Recommendation Report for Planning Permission for Works or Extension to a Dwelling

REF NO: P/82/19/HH

LOCATION: 23 Bishops Close
Pagham
PO21 4QR

PROPOSAL: Single storey side and part rear extension.

Drawing No.: 1933_PL03 Rev.: -

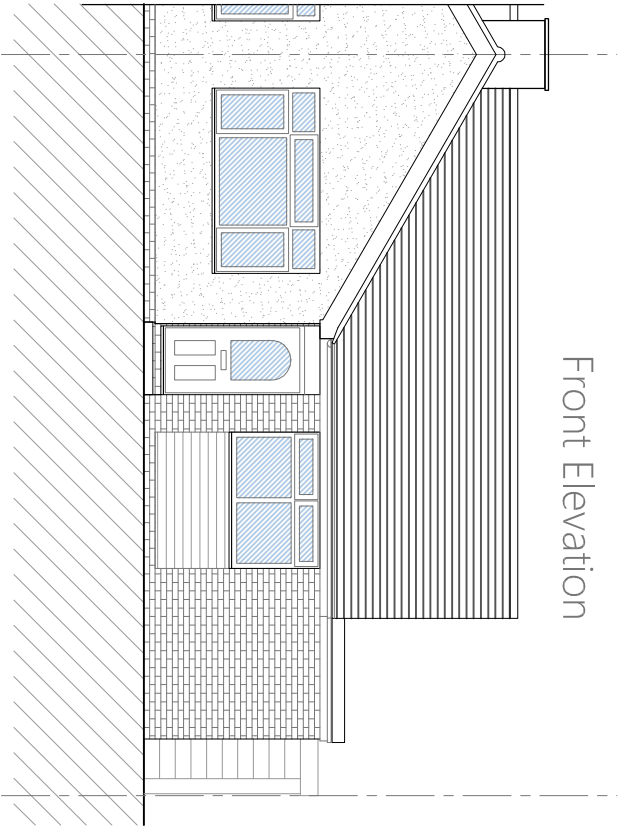
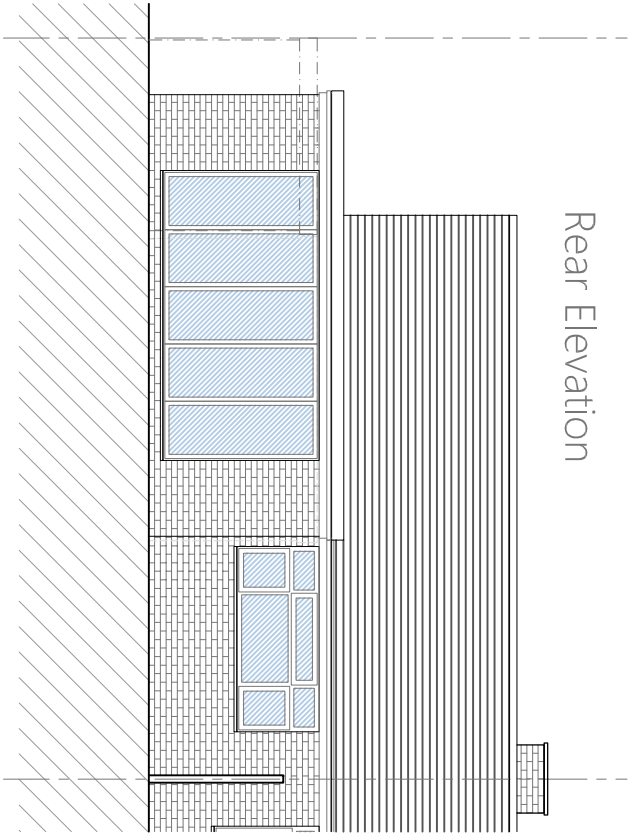
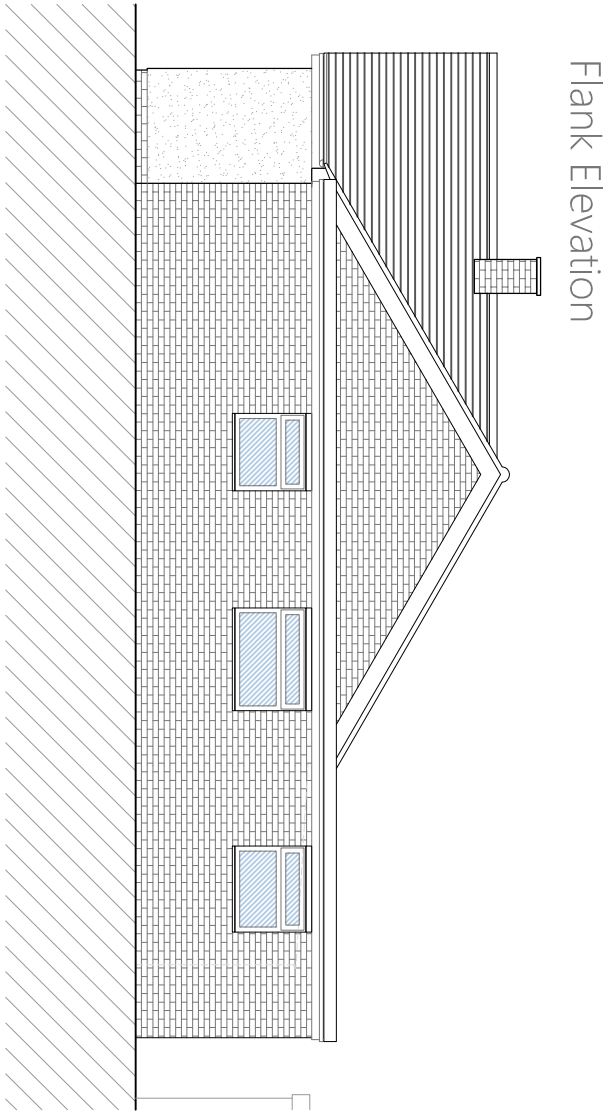
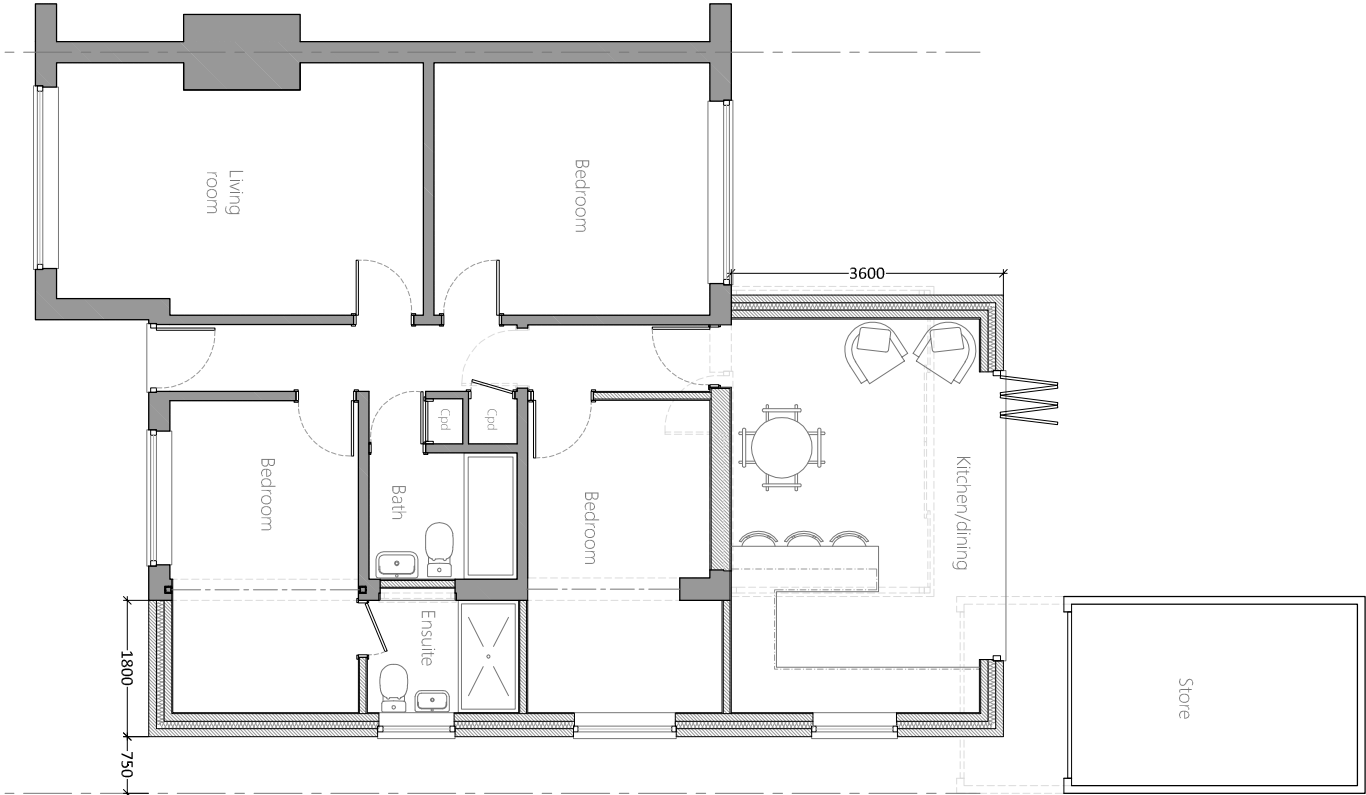
The extension will have a width of 1.8m running along the principal elevation. The eaves height will match that of the existing dwelling and due to its modest size and matching materials it appears well integrated with the host dwelling.

The extension will have a width of 1.8m to the north eastern elevation. This only retains 0.75m to the boundary property and therefore sits close to the boundary. The extension will run along the full side elevation and extend beyond the rear by 3.6m. It will have a flat roof with a height of 2.55m. The extension will run along part of the rear however retain 3.1m to the southern boundary.

3 windows are proposed to the side elevation. Whilst this is very close to the neighbouring elevation, which also has 2 windows, it is not considered to result in additional adverse overlooking in which a refusal is justified. This is due to one of the windows already being in existence and with the another being situated where there is an existing glass conservatory, as a result, it is not considered overlooking will increase significantly from that which already exists from standing in the driveway. The windows to the neighbouring property are also obscured glazed, small and at a relatively high level.

The rear addition is largely a replacement and is not considered to appear overbearing or overshadowing due to its modest height and depth. Due to the size and siting, the proposal is considered to accord with D DM1 and D DM4 of the Arun Local Plan.

The existing garage situated to the rear corner will be reduced in depth by approximately 1.3m to allow room for the rear extension. This will result in the the loss of garage however with sufficient space retained for the parking to the front for approximately 2 cars, the development is not considered to adversely impact upon highway or parking in the area.
